Ribble Valley Borough Council
Housing & Development Control

Application no: **3/2021/0760**

Address: **Springwood Drive Whalley BB7 9XL Phase 2 Lawsonsteads**

The Local Highway Authority have viewed the plans and highway related documents and have the following comments to make:

HOUSE TYPE C
3B6P

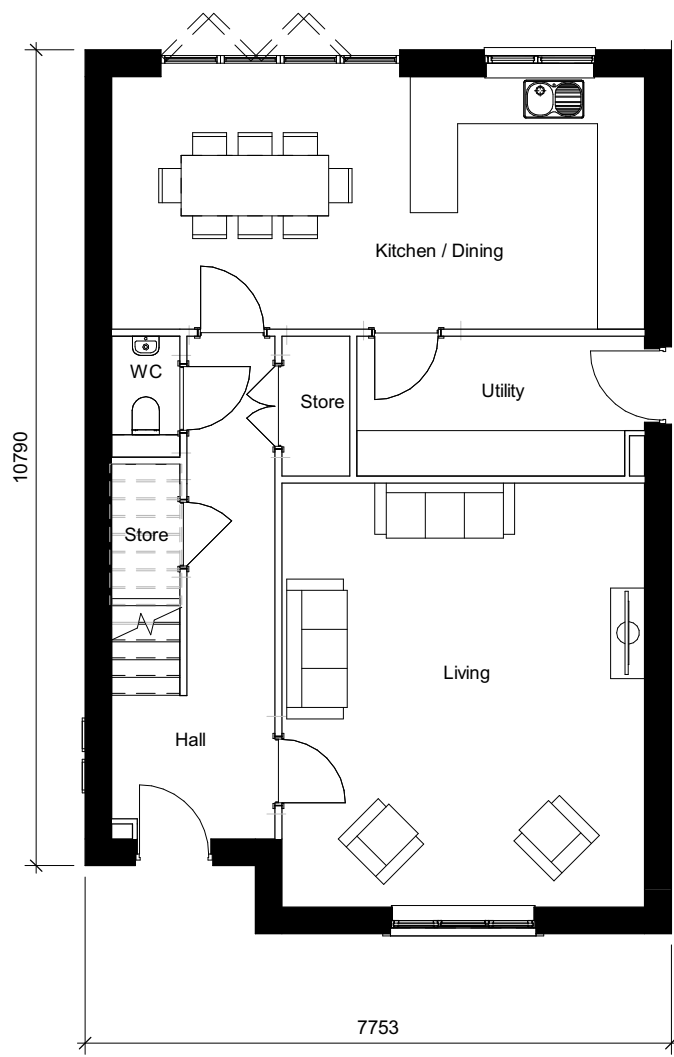
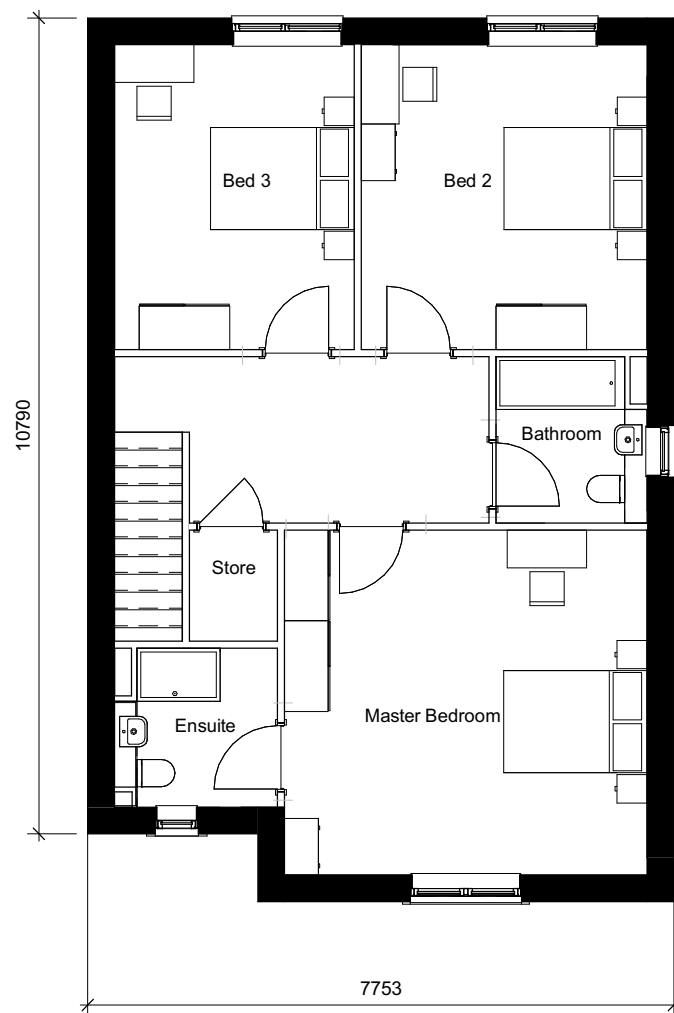
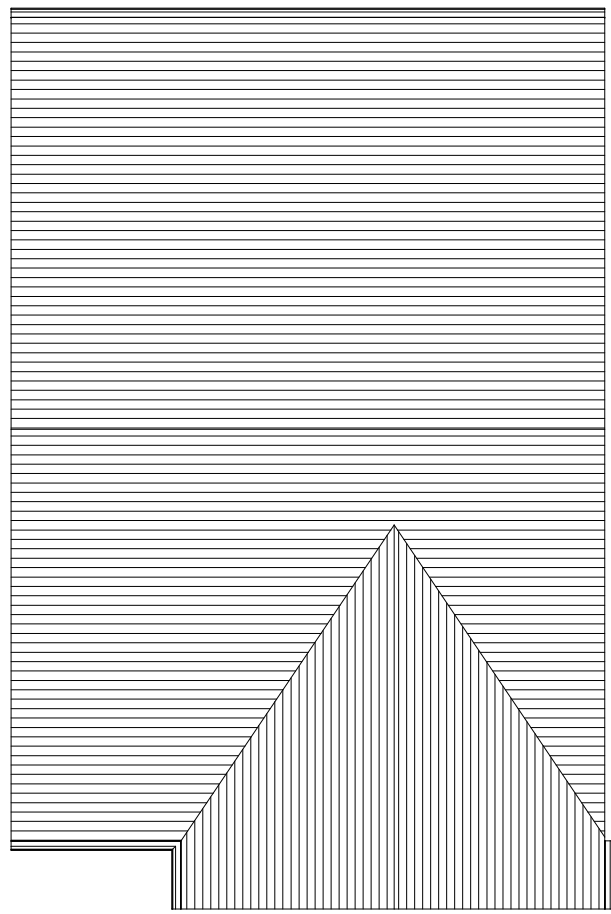
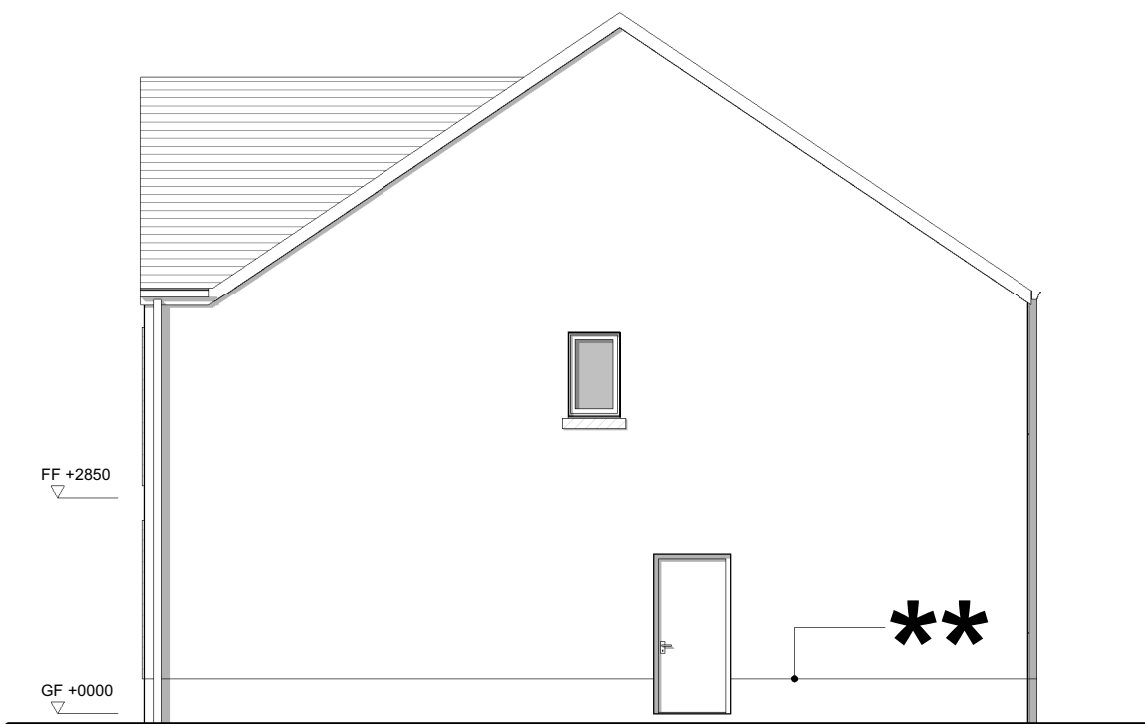
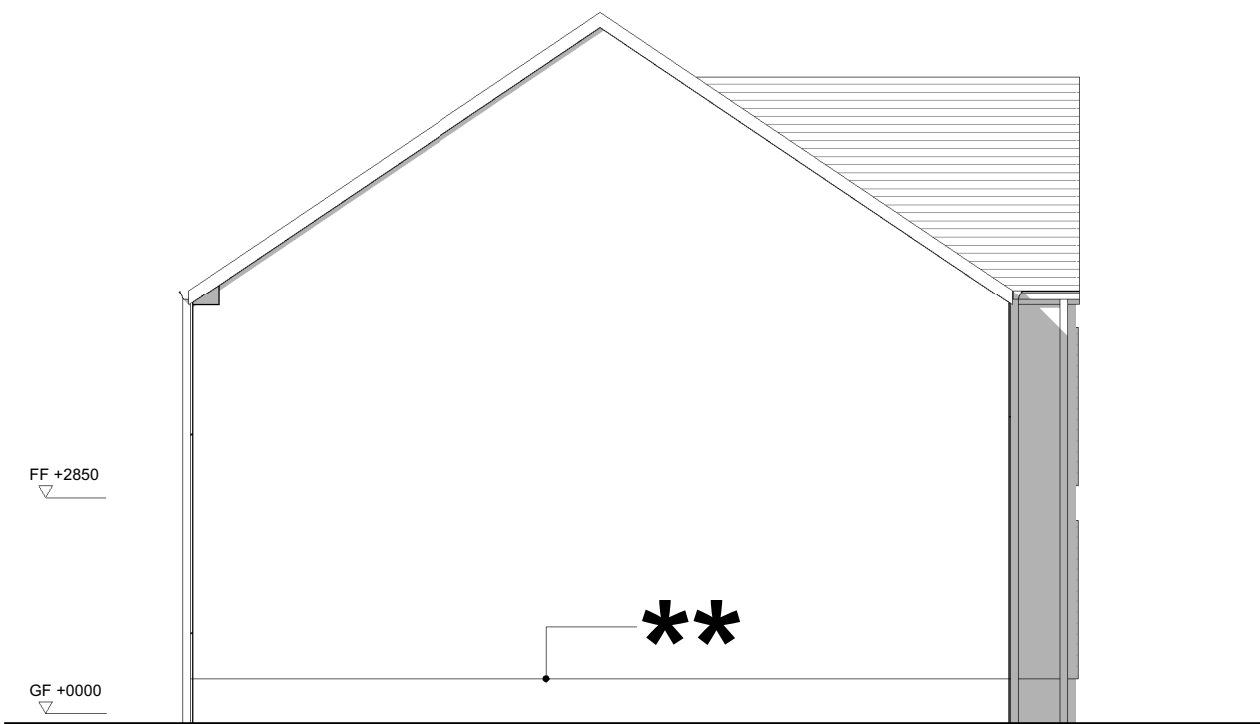
The LHA have no objection to the other planned amendments at the site which includes amending Type C from a 4-bed dwelling with an integral garage to a 3-bed dwelling without a garage; Plot 157 increasing in size; an additional window being added to bedroom 2 at Type K and changes to the layout at plots 82-84.

HOUSE TYPE E
4B8P

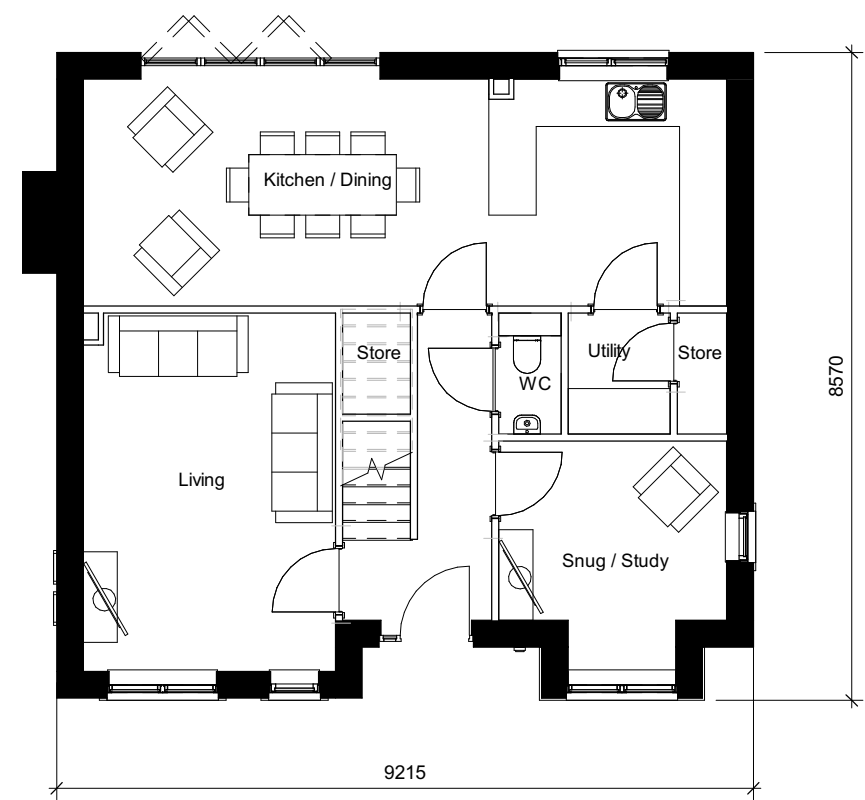
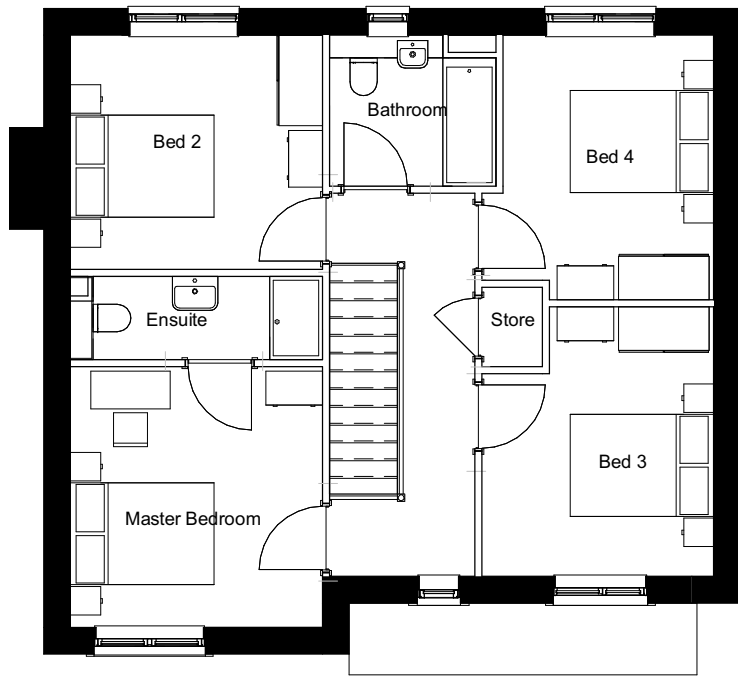
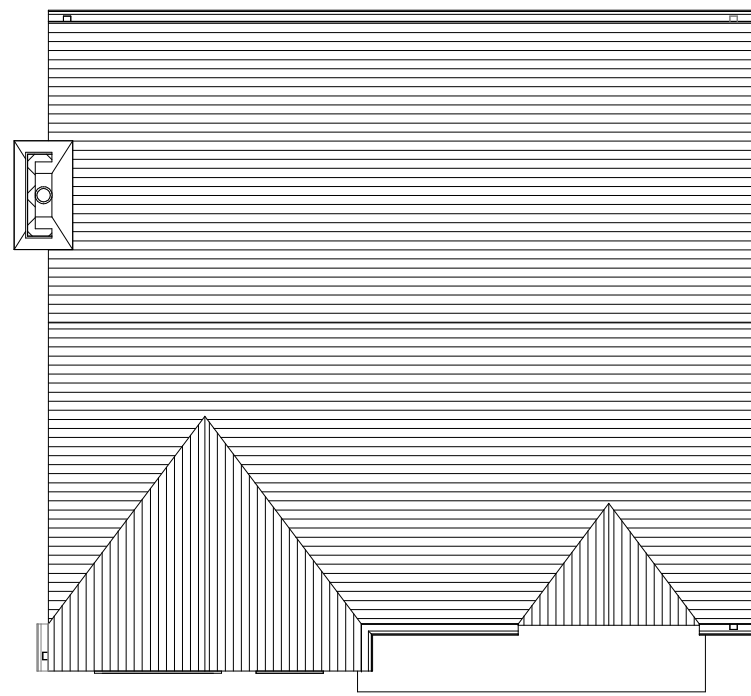
The LHA are aware that Plots 79, 86, 99, 102, 109 and 113 will change from a 3-bed to a 4-bed dwelling. For the Plots to comply with the Joint Lancashire Structure Plan, the LHA require a 4-bed dwelling to provide 3 car parking spaces.

The LHA have reviewed PRP drawing number Rev H titled "Proposed Site Plan (GF Plans)" and are satisfied that Plots 79, 86, 99, 102, 109 and 113 are able to comply with the LHAs parking standards and so the LHA have no further comments to make.

1. The development hereby permitted shall not be occupied until such time as the parking and turning facilities have been implemented in accordance with PRP drawing number Rev H. Thereafter the onsite parking provision shall be so maintained in perpetuity.
